# Consultee Comments for Planning Application 23/02901/FUL

Application Number: 23/02901/FUL

Proposal: Demolition of existing glass house and construction of 2 no. units of 2 bedroom tourist accommodation and associated works.

On Behalf Of: Coastal And Drainage Engineer

Proposed Site Plan
Scale 1:250@A3

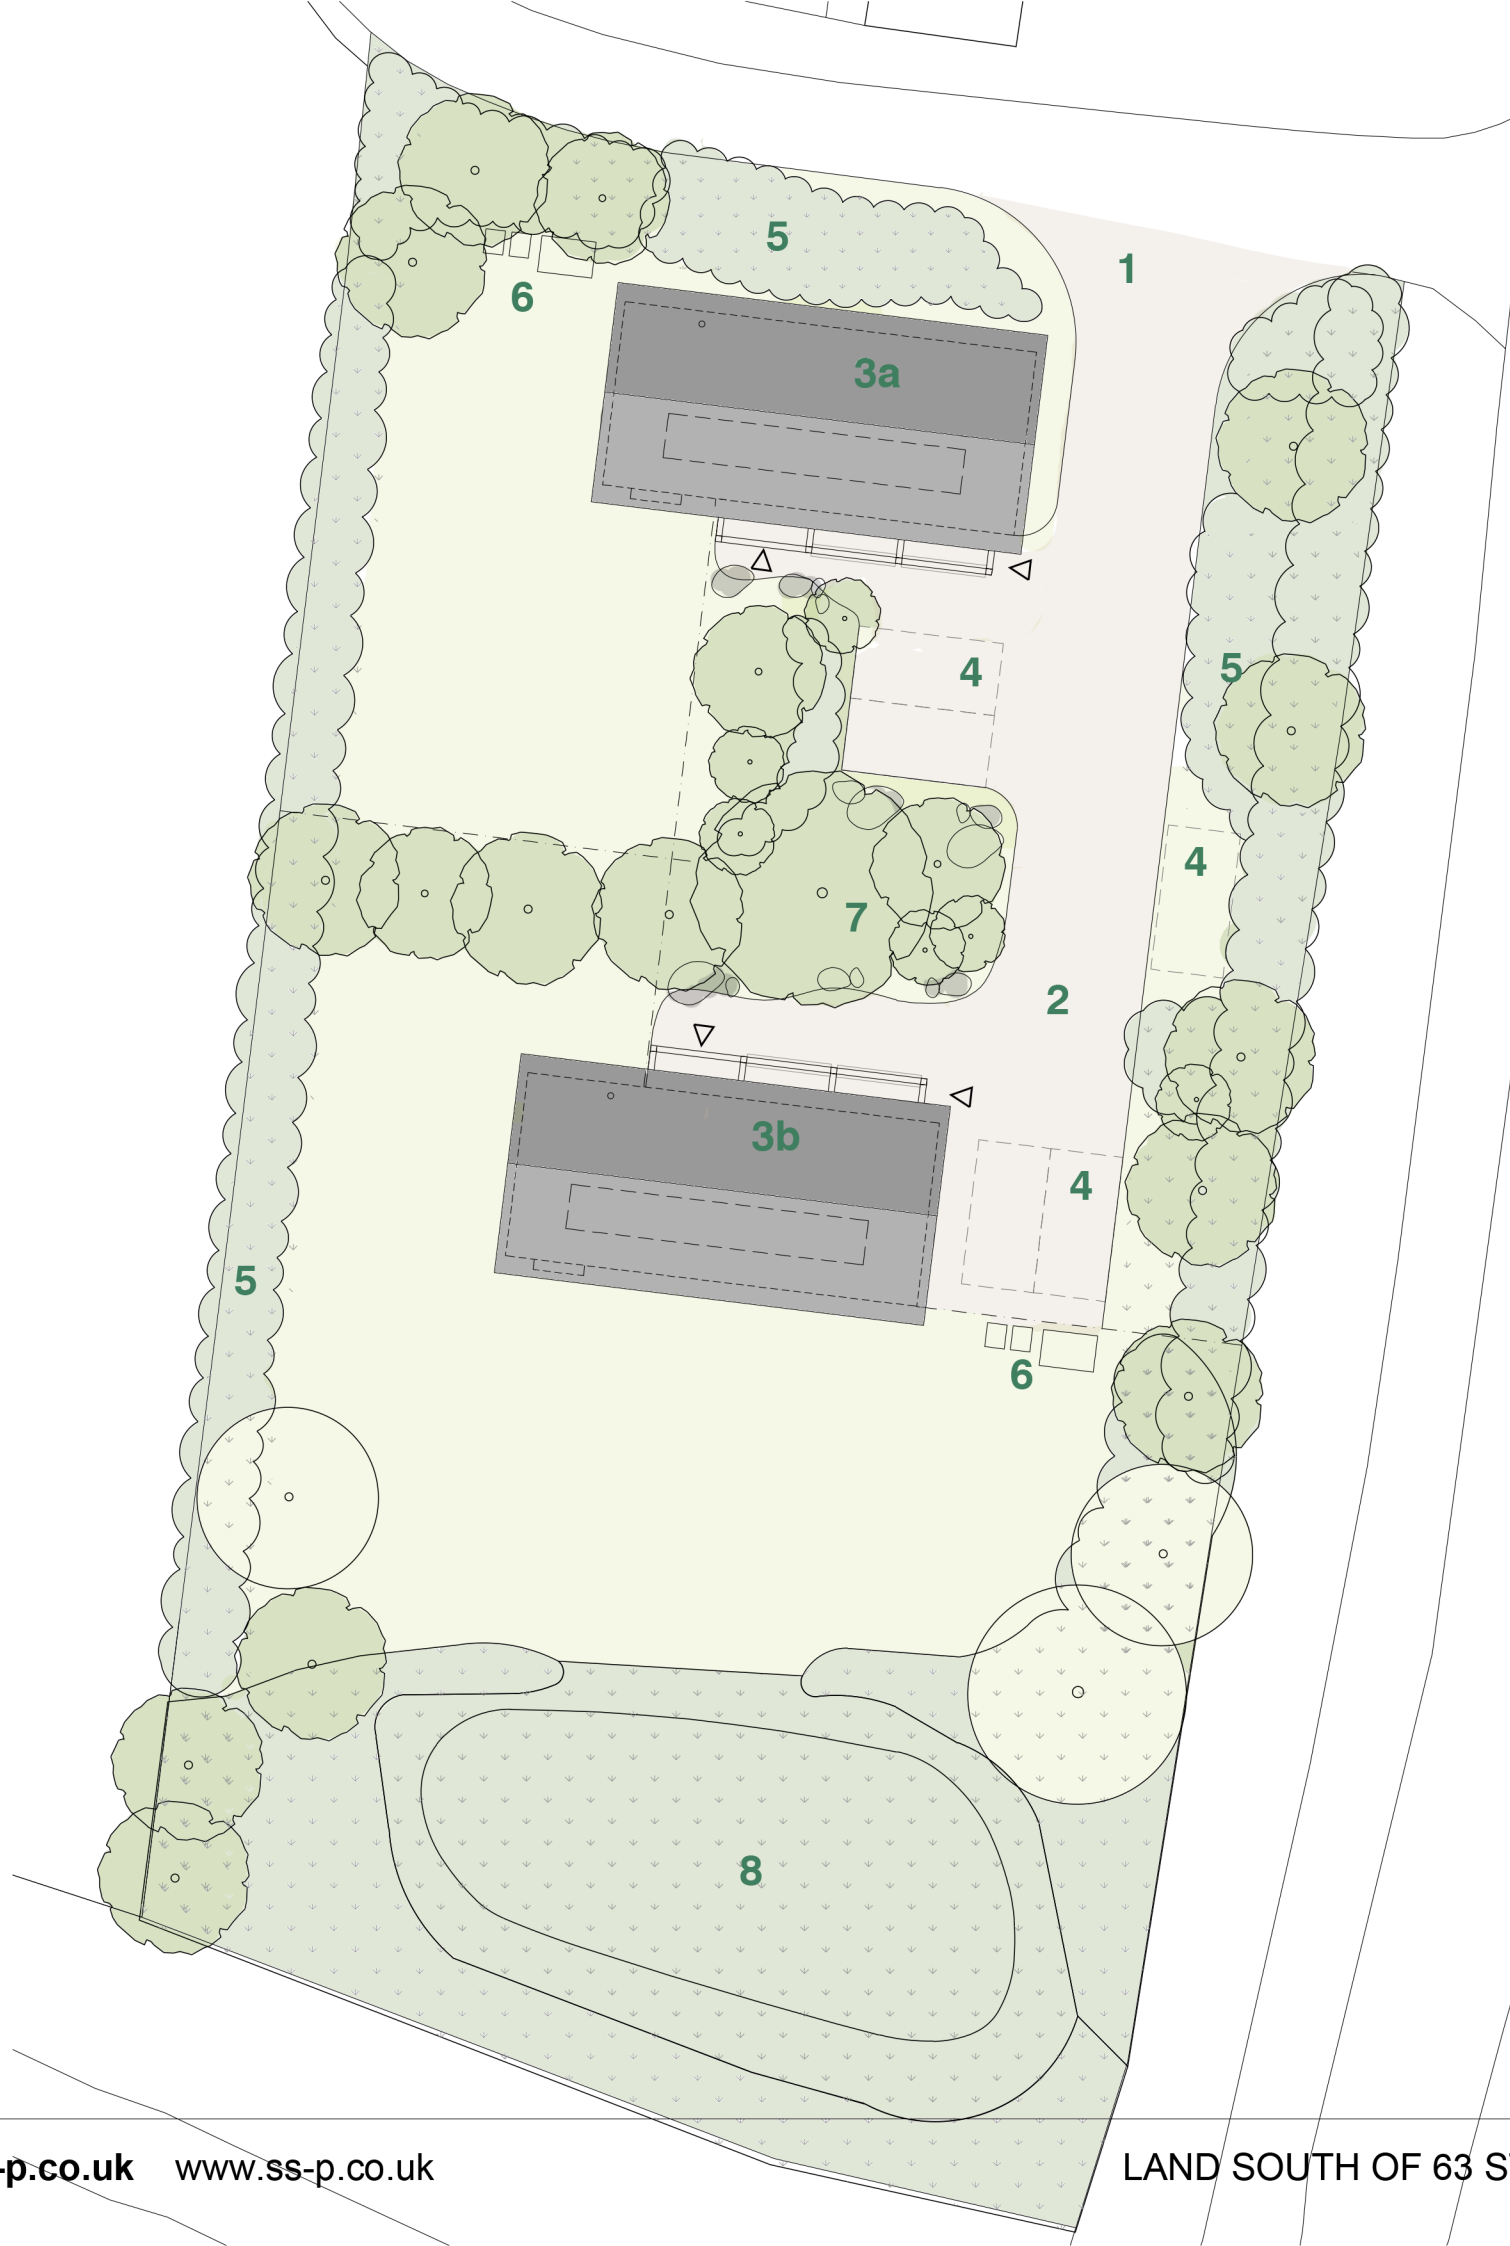
The documents submitted in support of this application suggest that the proposed means of surface water drainage is through on-site infiltration via soak-away structures and the use of permeable surfaces. This approach is acceptable in principle as it follows the hierarchy of preference as set out in Approved Document H of the Building Regulations and the SuDS Manual produced by CIRIA.

However, I note the landscape proposals include a wetland area to the south of the plot, which is something we would be fully supportive of, as we really like to see space made for water. In my opinion as a drainage engineer; this presents an excellent opportunity to create a surface level, fully functional SuDS system, where the wetland not only provides ecological enhancement to the site but is also used to drain the development (which would be preferable to the use of subterranean plastic crates).

Wherever possible, driveways, parking spaces, paths and patios should be of permeable construction.
